City of Albuquerque
Stormwater Construction Site
Inspection Report

Project Name and Location	Guardian Storage 3606 Bosque Plaza Lane		
Site Contact Name & Agency	Paul Hedges Guardian Storage	ESC File No. NPDES ID No.	E12 E0066
Date of Inspection	1-18-19	Start/End Time	9:45/10:00
COA Inspector Name	Curtis Cherne, Stormwater Quality		
Describe Present Phase of Construction	exterior work		
Type of Inspection:	<input checked="" type="checkbox"/> Regular <input checked="" type="checkbox"/> During storm event <input type="checkbox"/> Post-storm event (> 0.25 inch) <input type="checkbox"/> 311 / Complaint Response <input type="checkbox"/> Follow-Up

Addendum to Stormwater Construction Site Inspection Report

TITLE: GUARDIAN STORAGE EROSION & SEDIMENT CONTROL PLAN

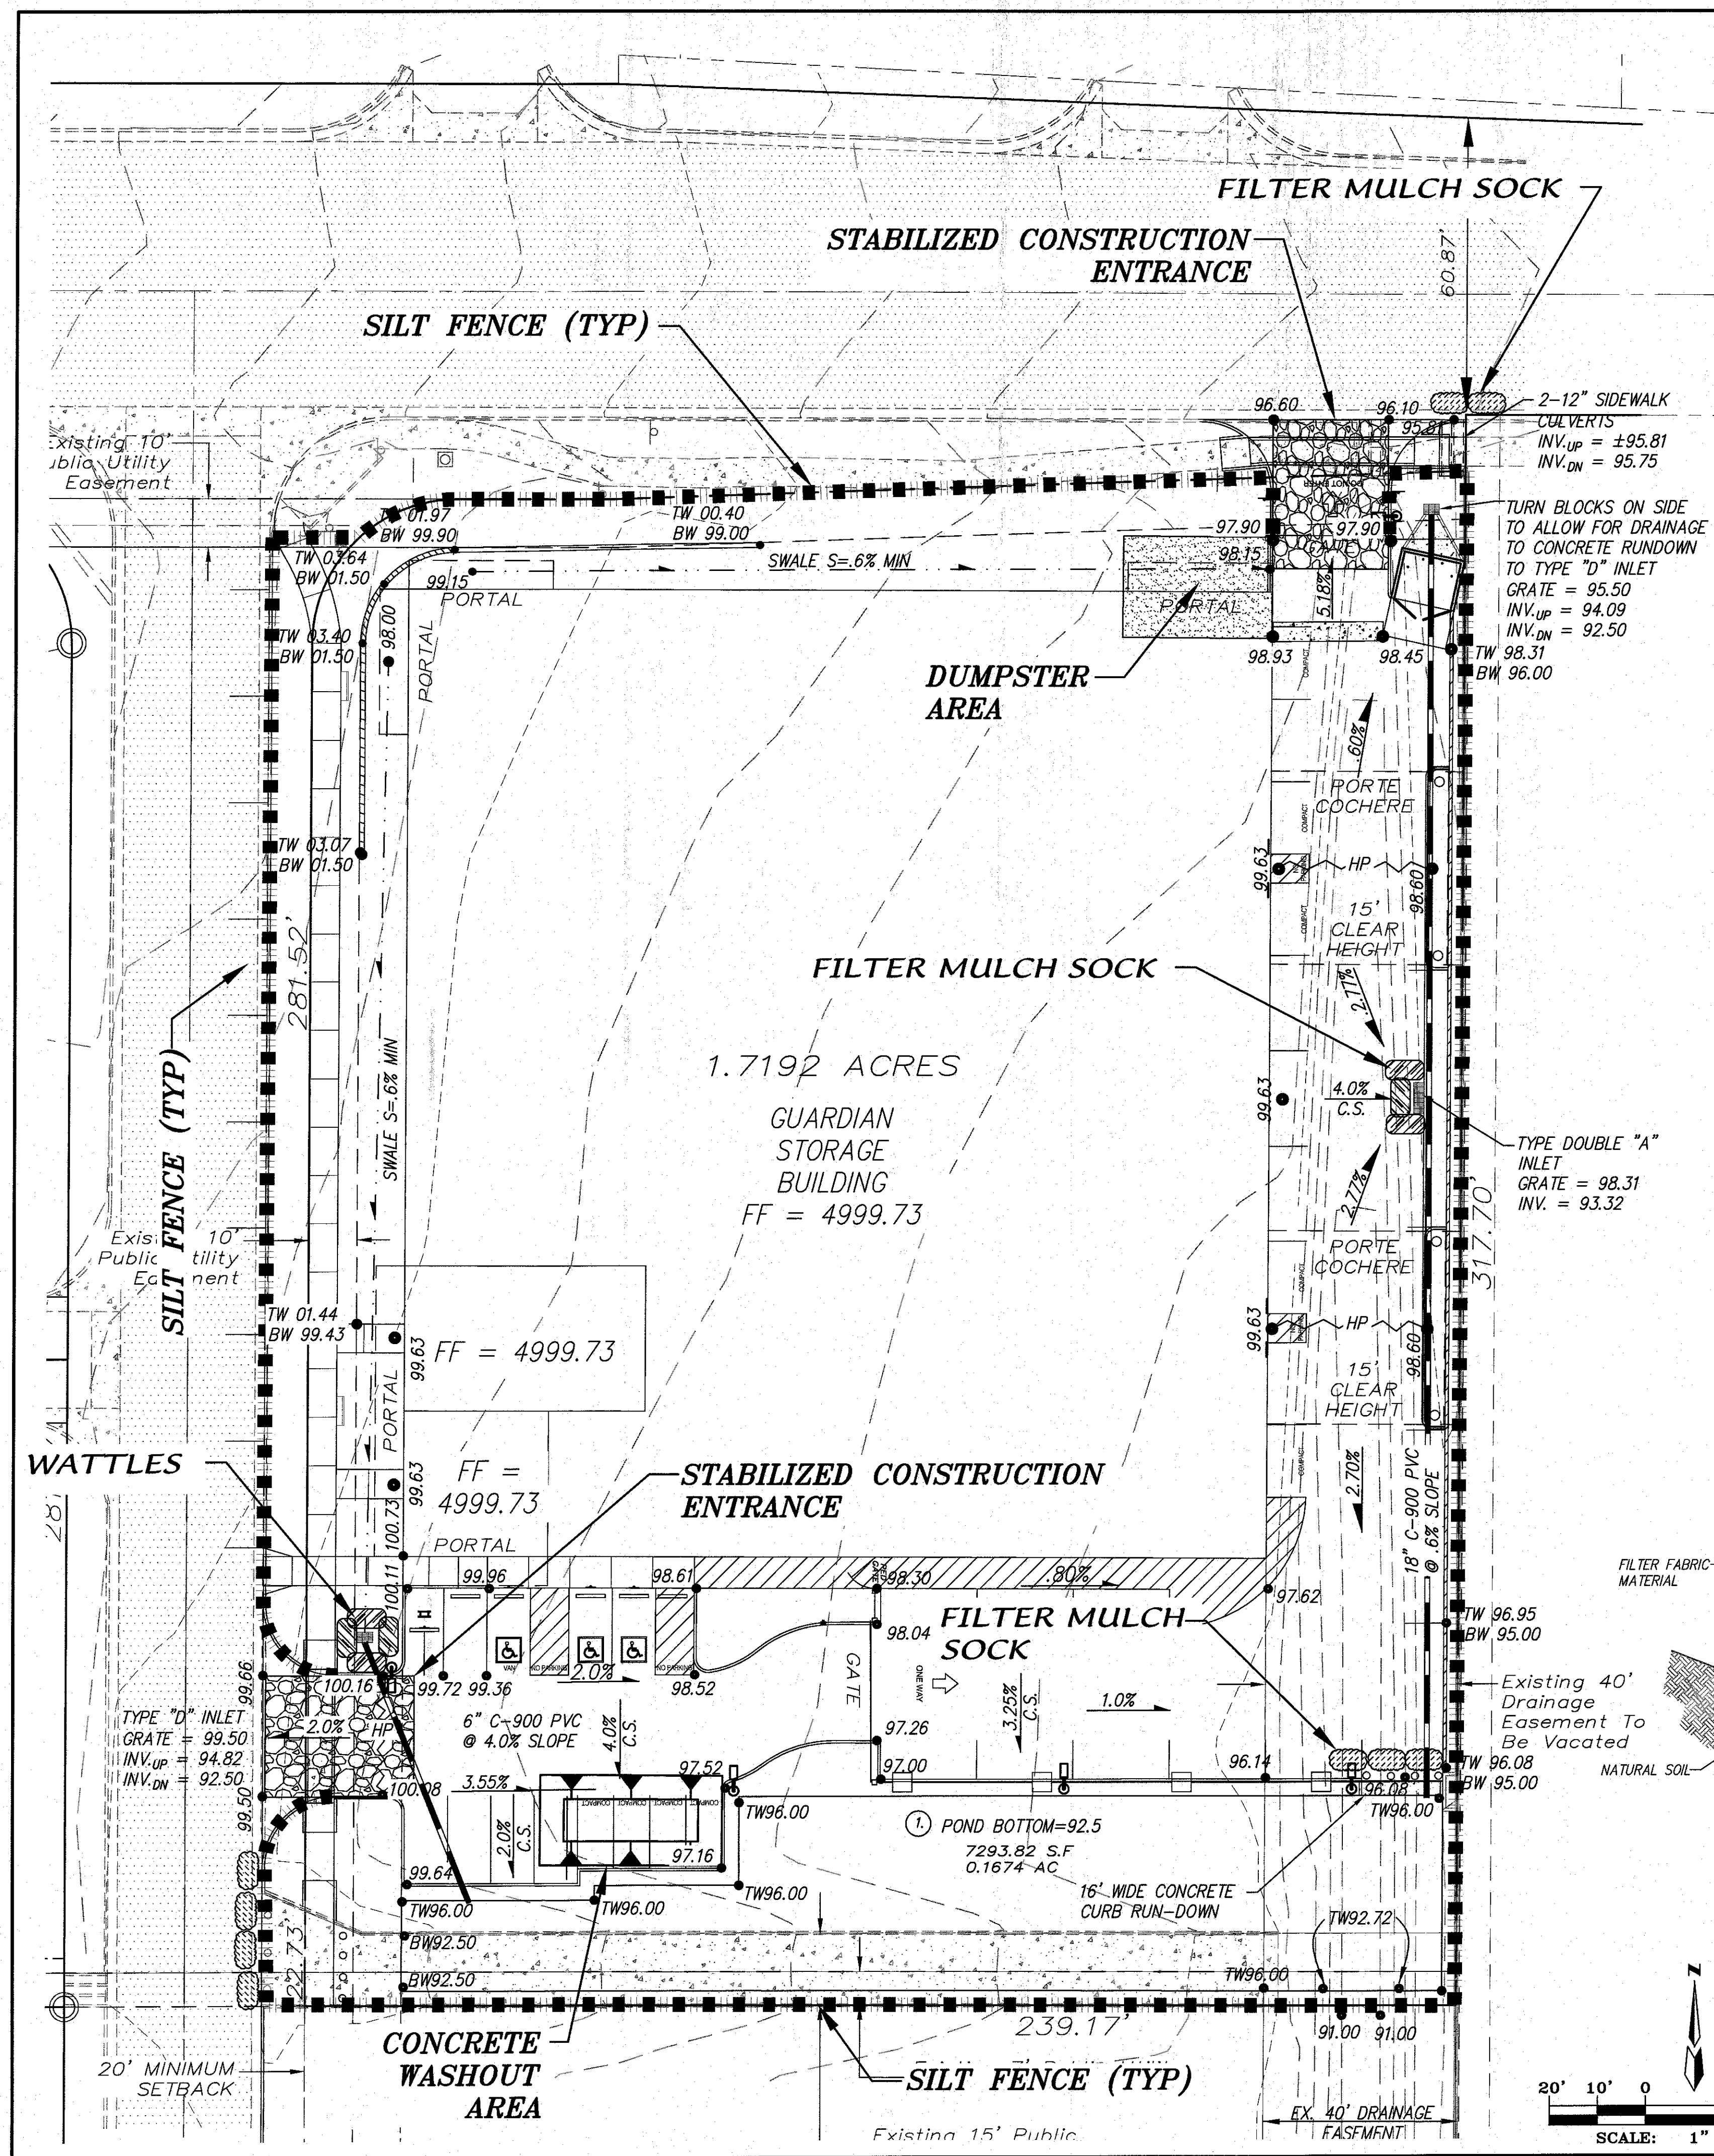
CGP ¹ Section	BMP / Activity	Maintenance or Corrective Action Required	Location and Notes
1.5	Post a Notice		
2.2.1	Provide and maintain Natural buffer when Waters of the US < 50 ft		
2.2.3	Sediment control along any perimeter	✓	gap in silt fence north side
2.2.3	Sediment control along any perimeter		
2.2.3	Sediment control along any perimeter		
2.2.3	Sediment control along any perimeter		
2.2.3	Sediment control along any perimeter		
2.2.3	Sediment control along any perimeter		
2.2.3	Sediment control along any perimeter		
2.2.4	Minimize sediment track-out	✓	no USC - major track-out medium

2.3.3	Fuel, oil, hydraulic fluid, petroleum products and chemical storage		
2.3.3	Construction and Domestic Wastes	✓	waste in pond and overflow
2.3.3	Construction and Domestic Wastes	✓	dumpster not covered / no ability to cover

2.3.4	Washing Applicators used for paint, stucco, concrete, etc.	✓	wash-out - humorous
2.3.4	Washing Applicators used for paint, stucco, concrete, etc.	✓	no acceptable wash-out facility

Notes:	vehicles exiting muddy site and no CTC

2.2.3	Sediment control along any perimeter		
2.3.3	Construction and Domestic Wastes	✓	wastes not in dumpster - numerous
2.3.3	Construction and Domestic Wastes

Maintenance or corrective actions are to be completed within 7 days.
